USED CAR SALES
VICINITY OF 486 FOREST AVENUE
CONDITIONAL USE AND SITE PLAN REVIEW

MARCUS MOSCHETTO, APPLICANT

Submitted by:
Shukria Wiar, Planner

October 18, 2006

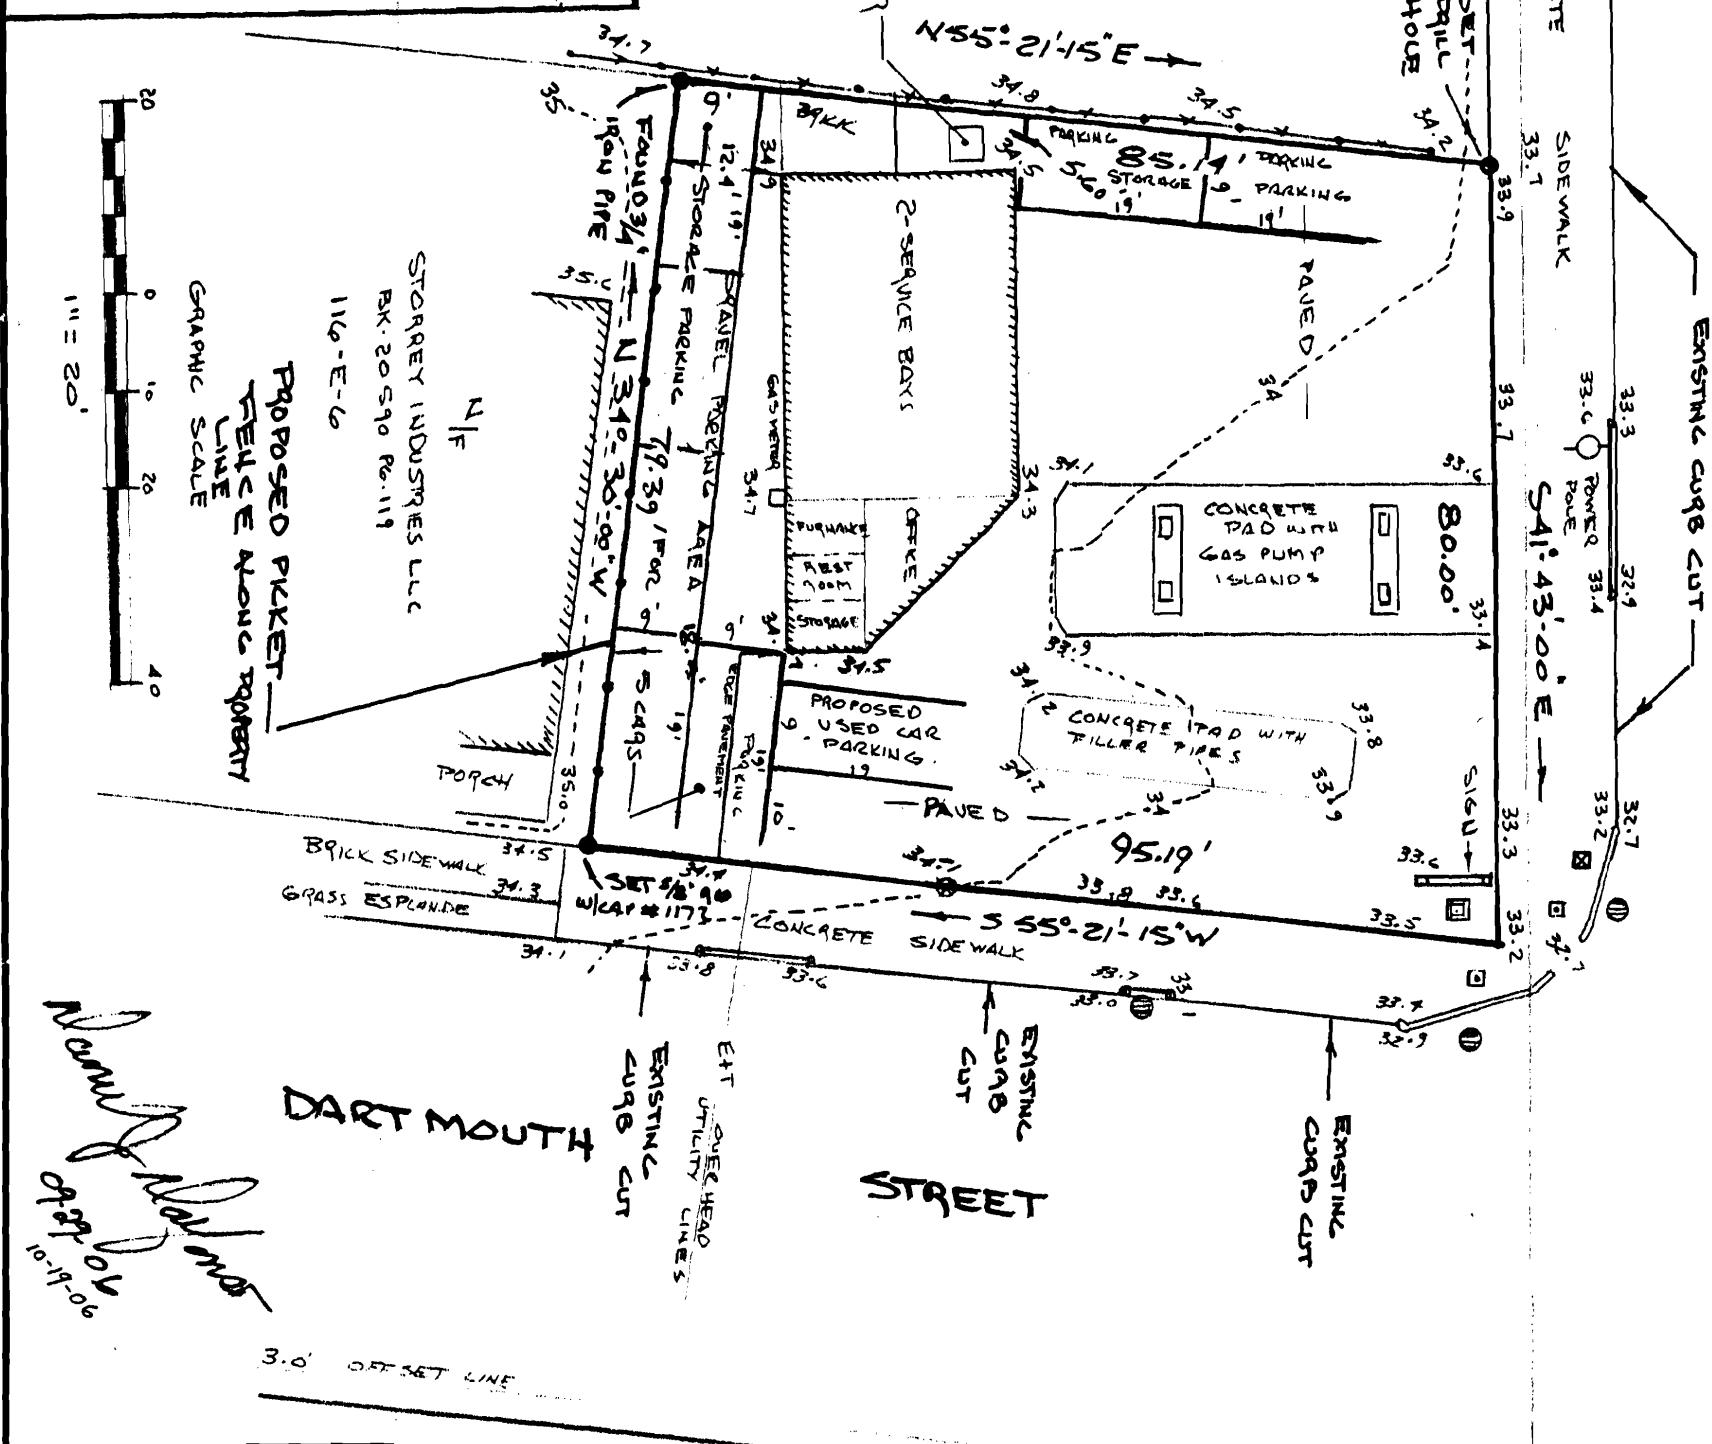
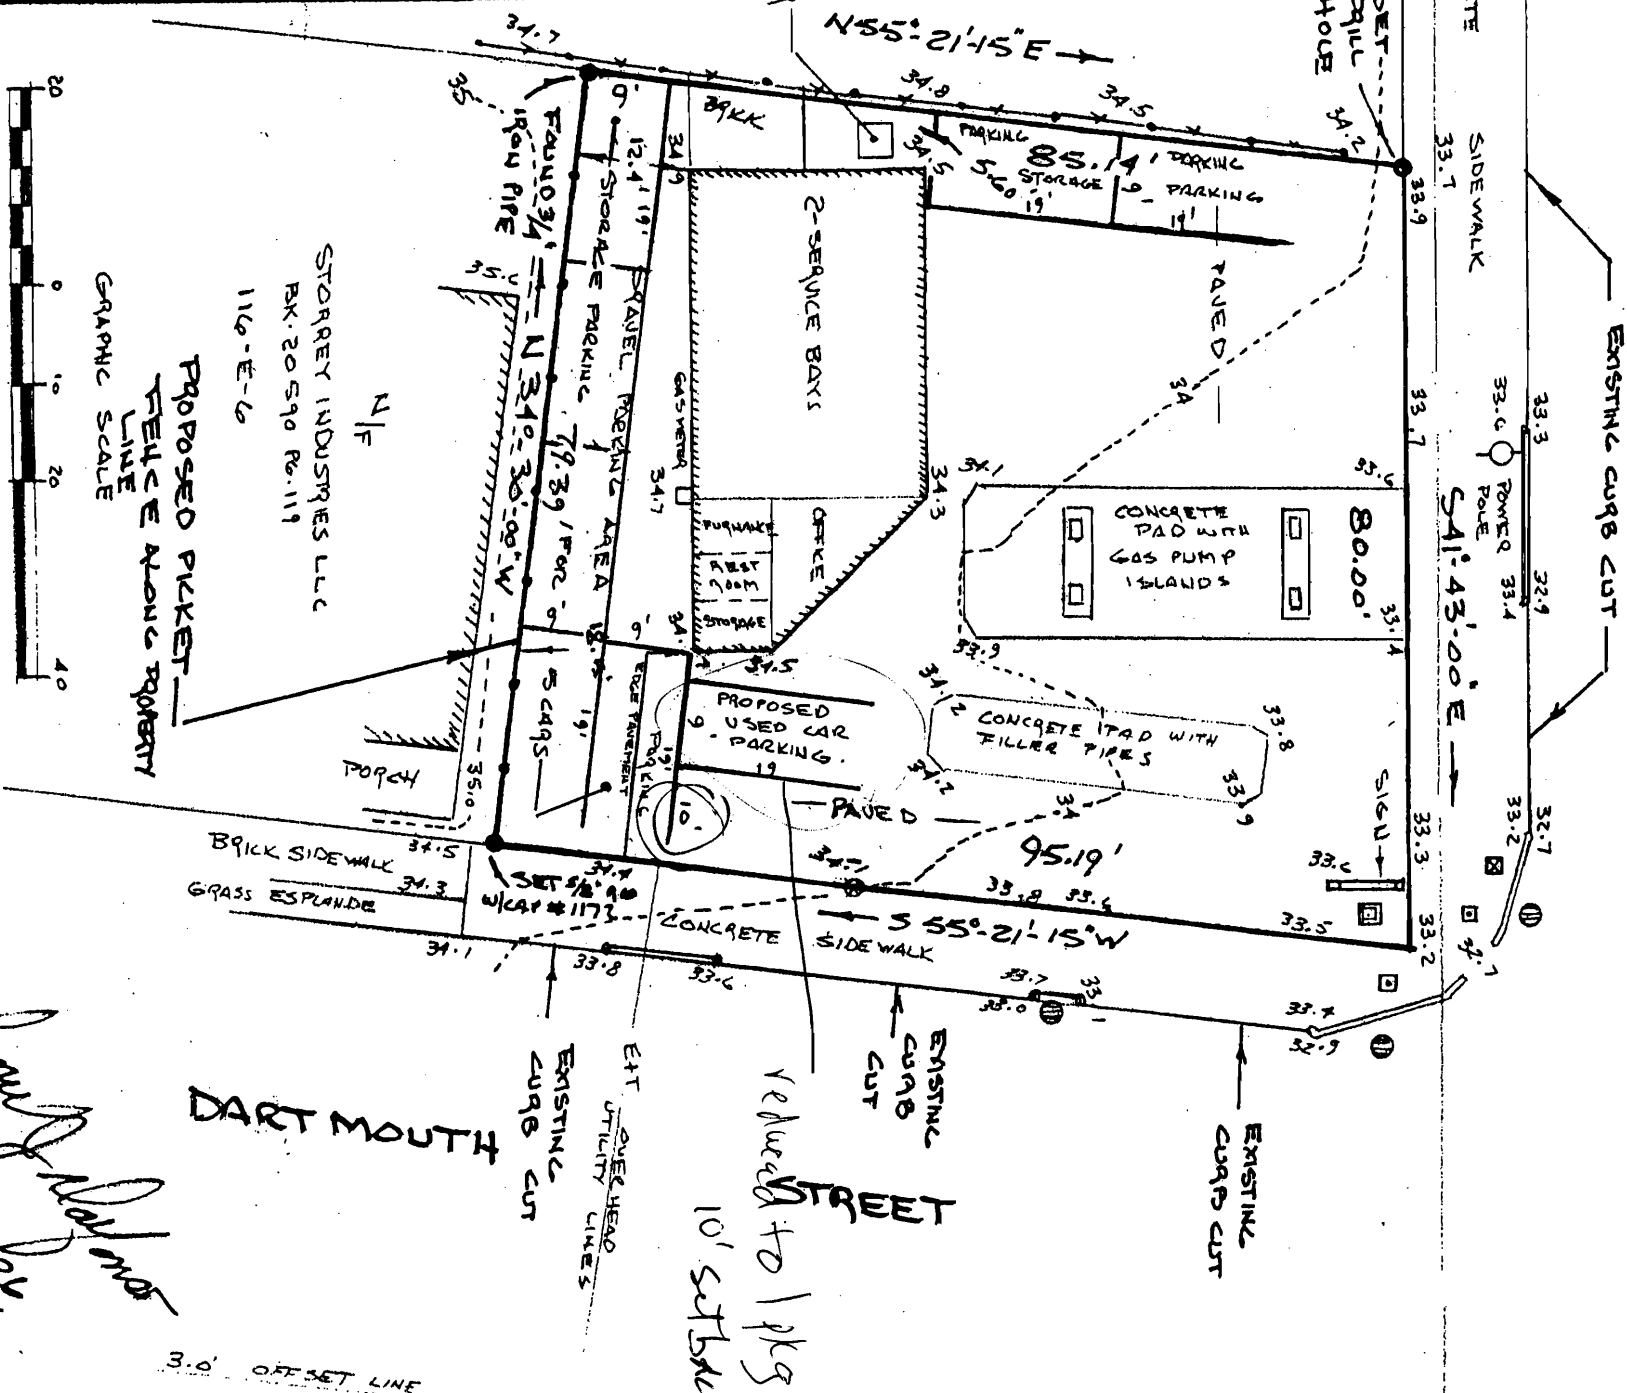
The Jim Carmody, Traffic Engineer reviewed the proposed plan, see Attachment 8. All vehicles on the site must be entirely within the property line. No vehicles are to encroach on the public sidewalks at any time.

Stationary vehicles cannot block driveways to the property. This would restrict access/egress to the gas station impacting the adjacent streets, and could become a safety problem.

- 1. All vehicles on the site must be entirely within the property line. No vehicles are to encroach on the public sidewalks at any time.*

The applicant is proposing a picket fence along the back of the property where it abuts a residential unit.
